Submission Form

Epping to Thornleigh Third Track Proposal. Application number SSI 5132.

Figure S.6 Cross-section and elevation - New Cheltenham Station concourse building (see also S.5 for artist's impression)

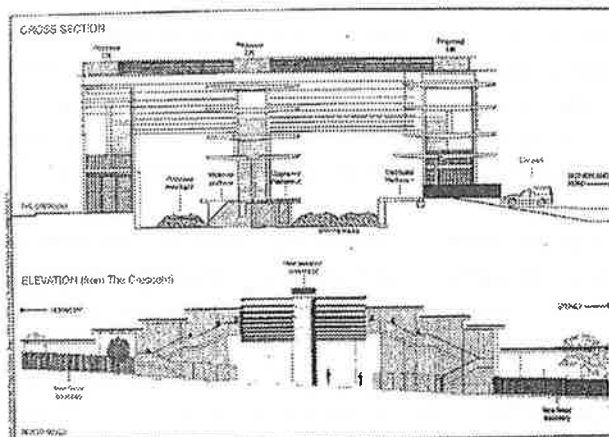
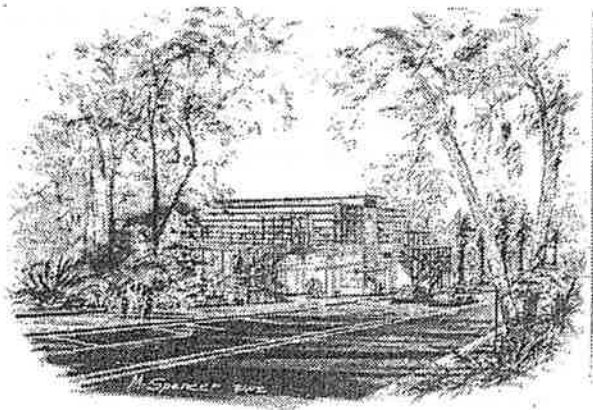
- The proposed redevelopment of Cheltenham Station shows no regard for the HCA. The visual impact of the proposed 13m high glass and steel concourse is totally unacceptable in this HCA.
